Recommendation Report for Planning Permission for Works or Extension to a Dwelling

REF NO: K/40/21/HH

LOCATION: 41 Coastal Road
East Preston
BN16 1SN

PROPOSAL: Replacement sun room with associated internal alterations

DRAWING TITLE  
**Plans as proposed**

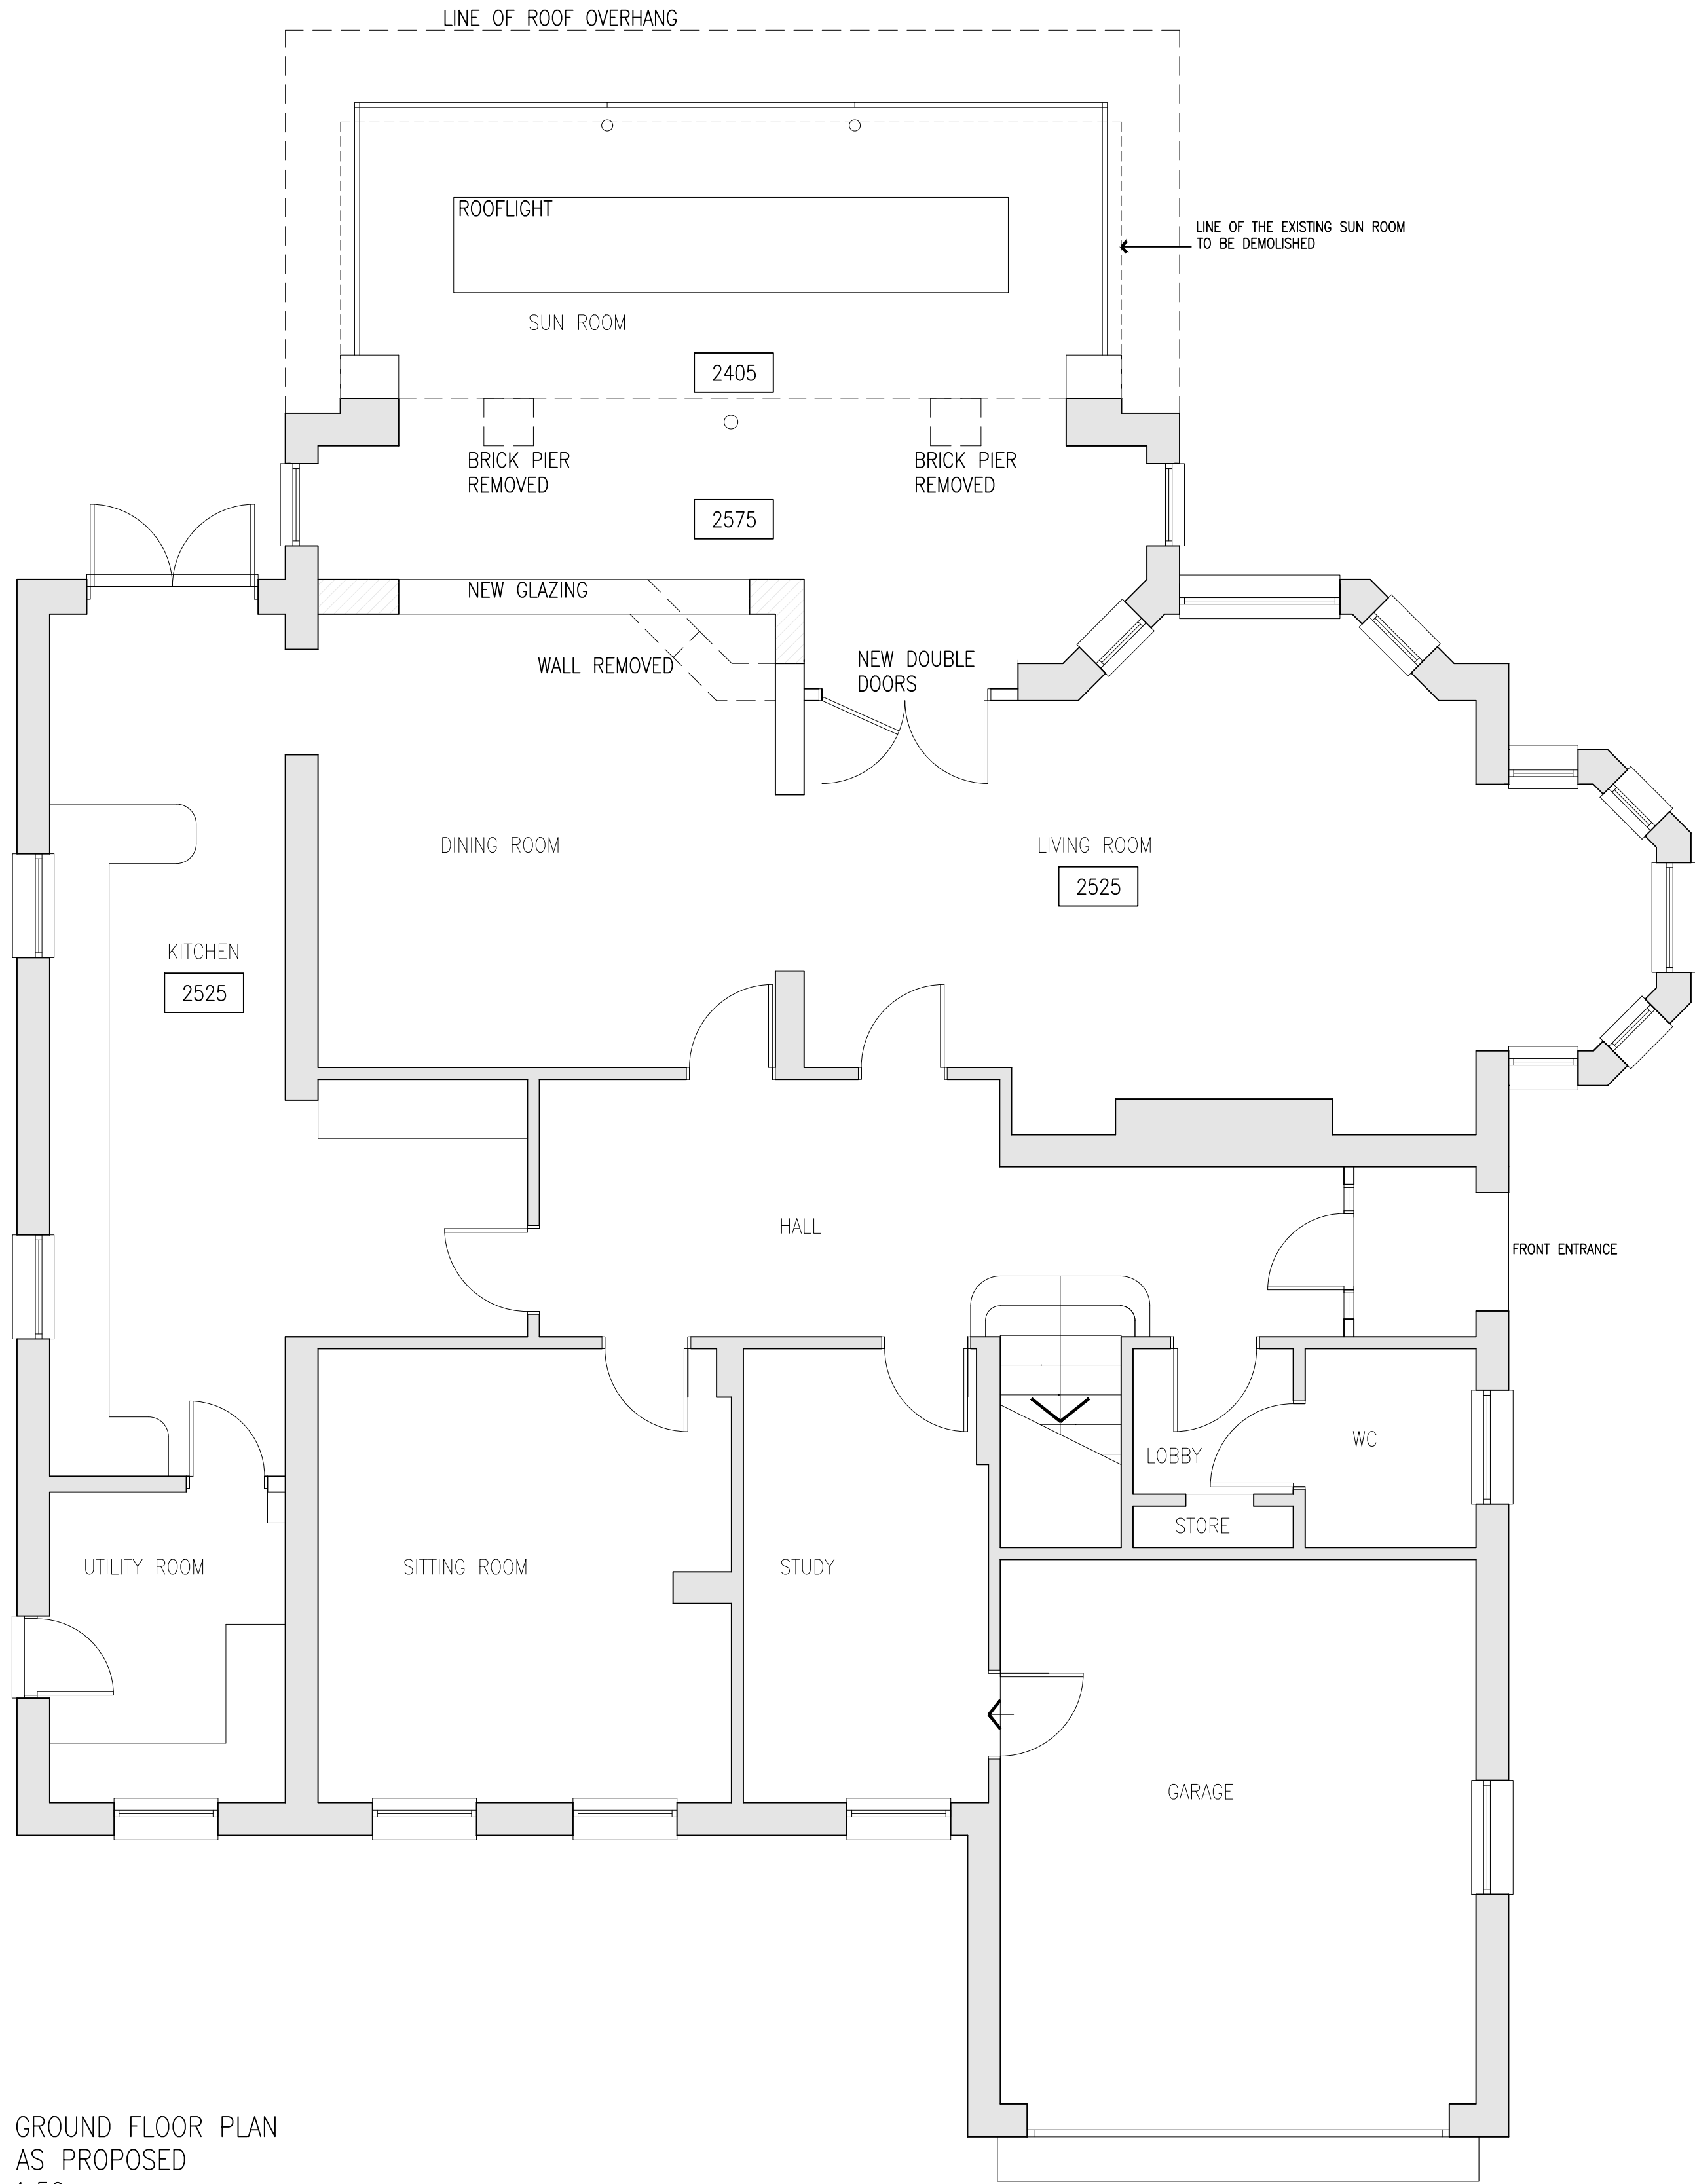
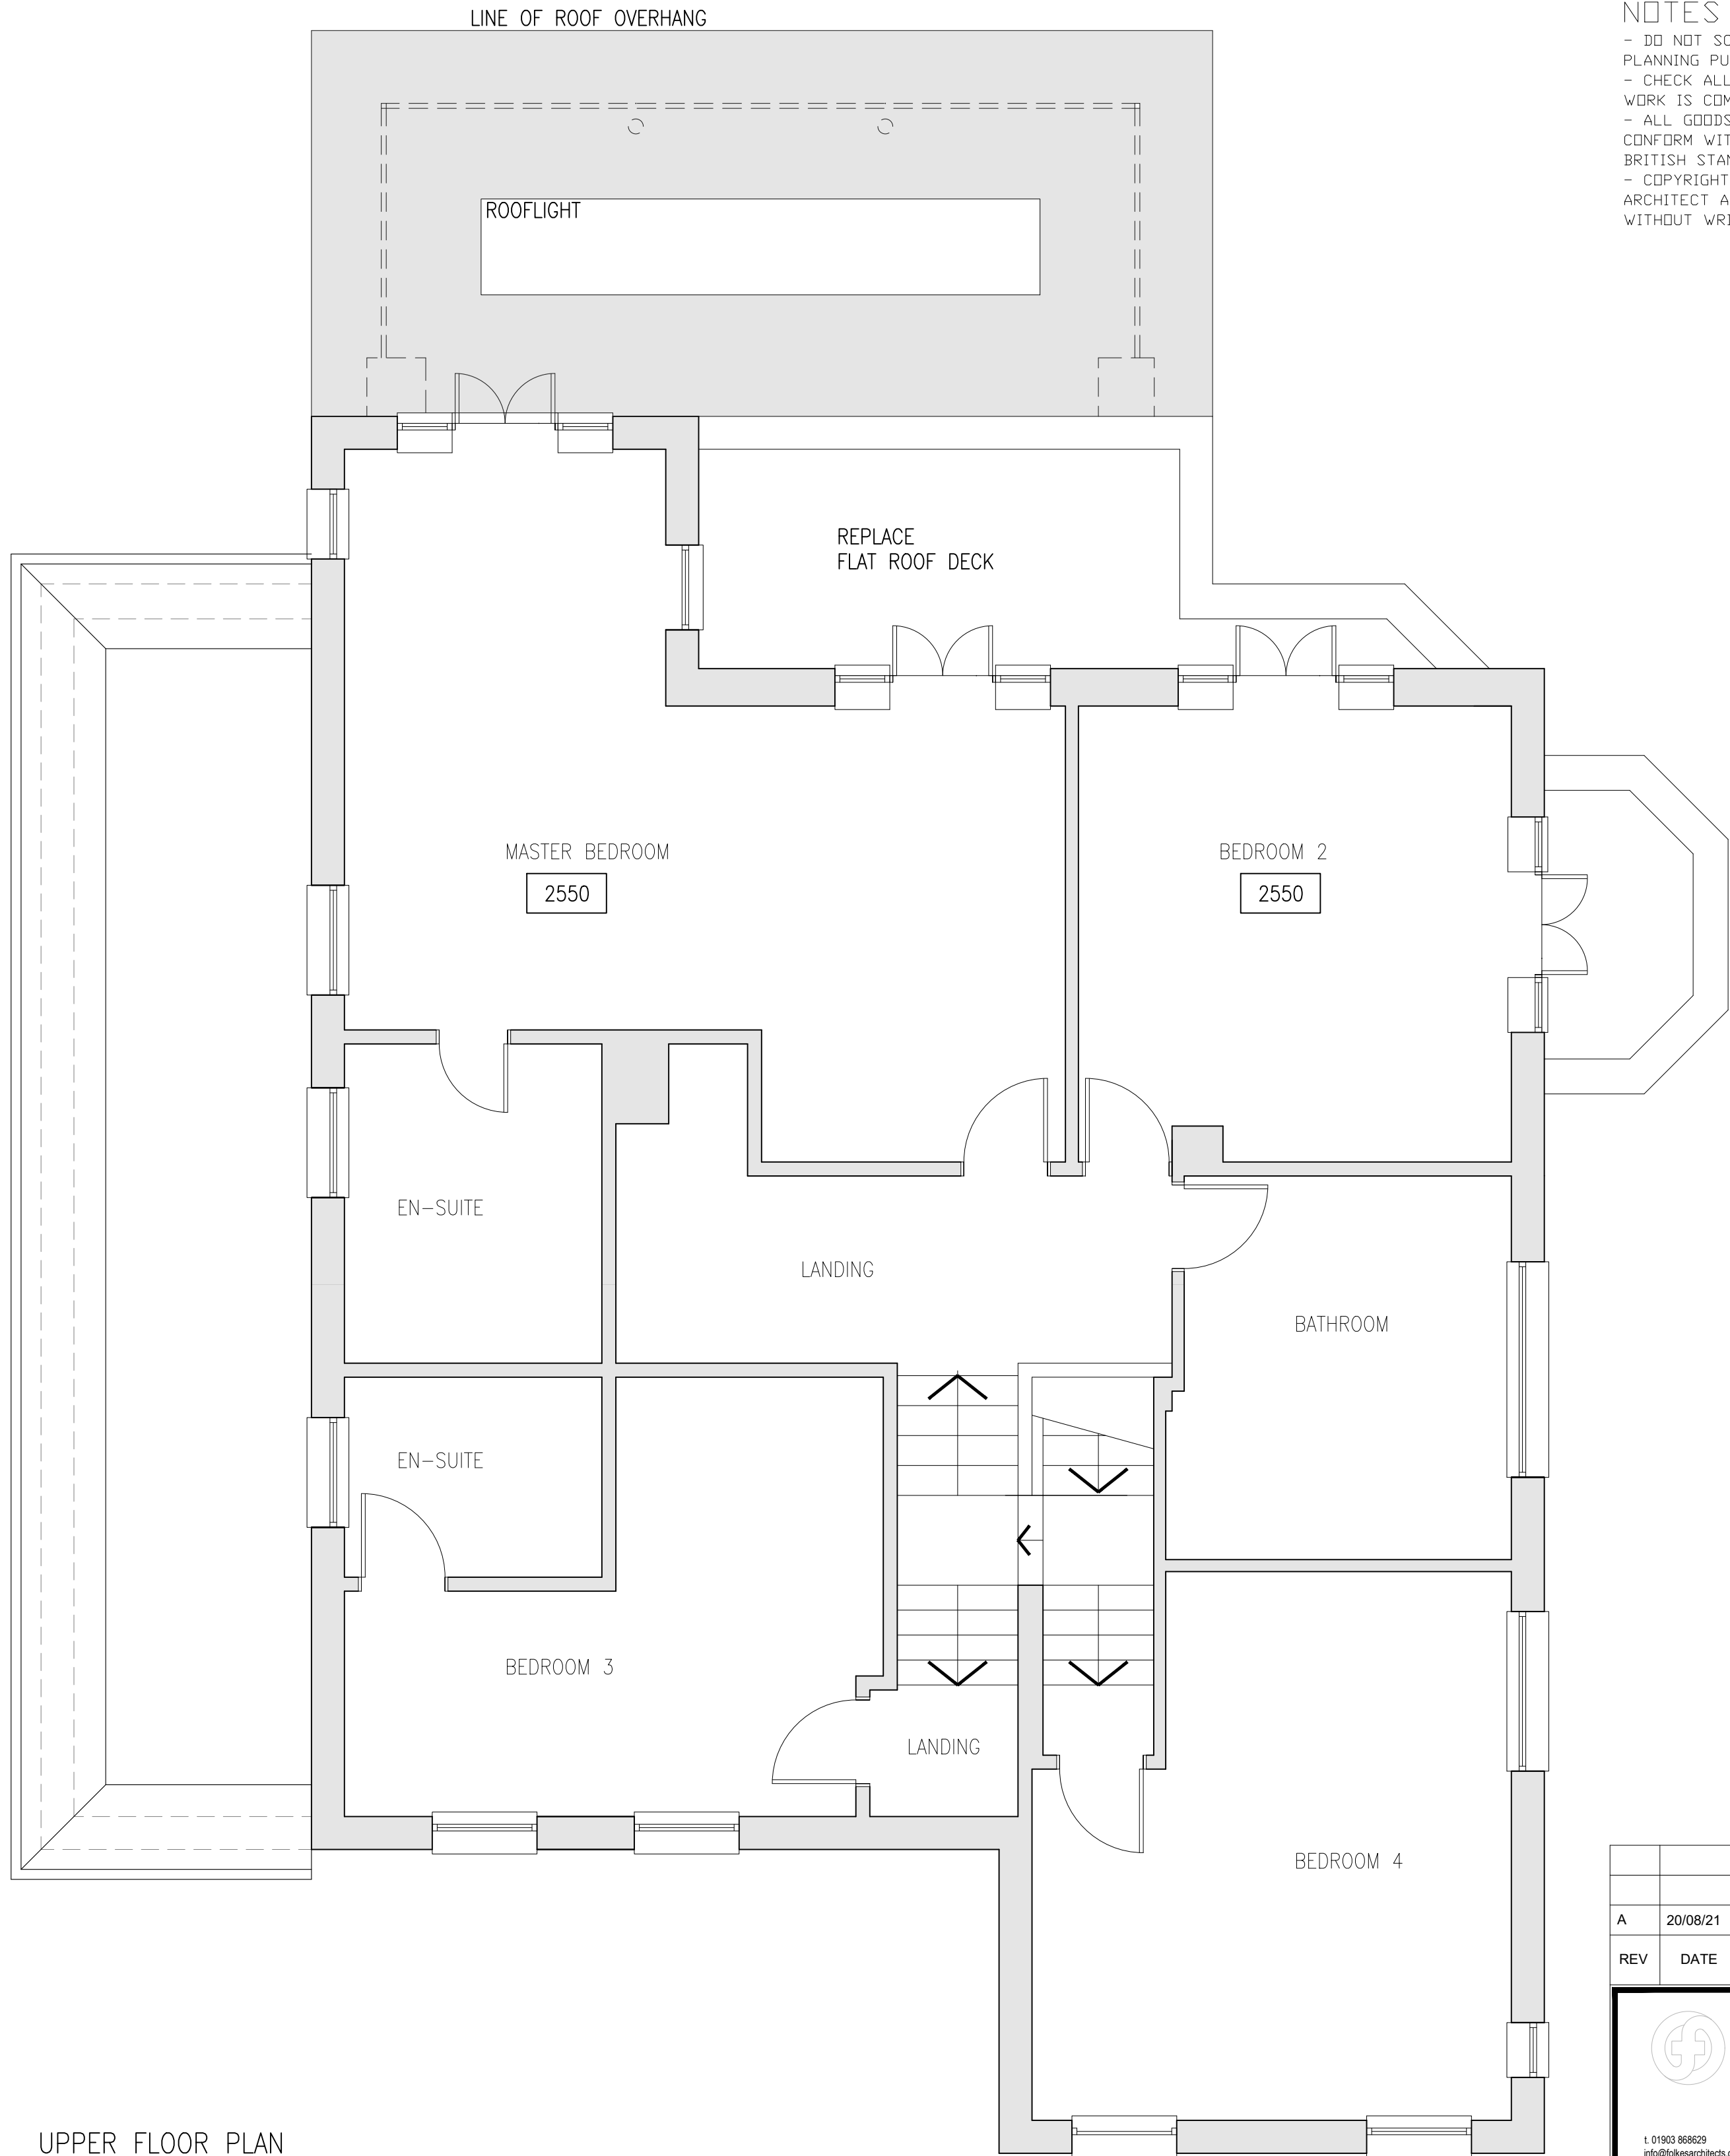
This sunroom extension will replace a similar structure currently on site. The proposed extension is to be 200mm longer; however, it will be 300mm less in width and 250mm lower in height. The amount and scale of the proposed is considered equal to that which exists. The extension is not visible from the street and it has a much lower scale than that of the host dwelling, as such it is considered subservient to the host dwelling and its surroundings.

The proposed structure will replace a similar structure. The replacement structure will be located centrally within the rear elevation of the property and as such will cause no overbearing or overshadowing issues.
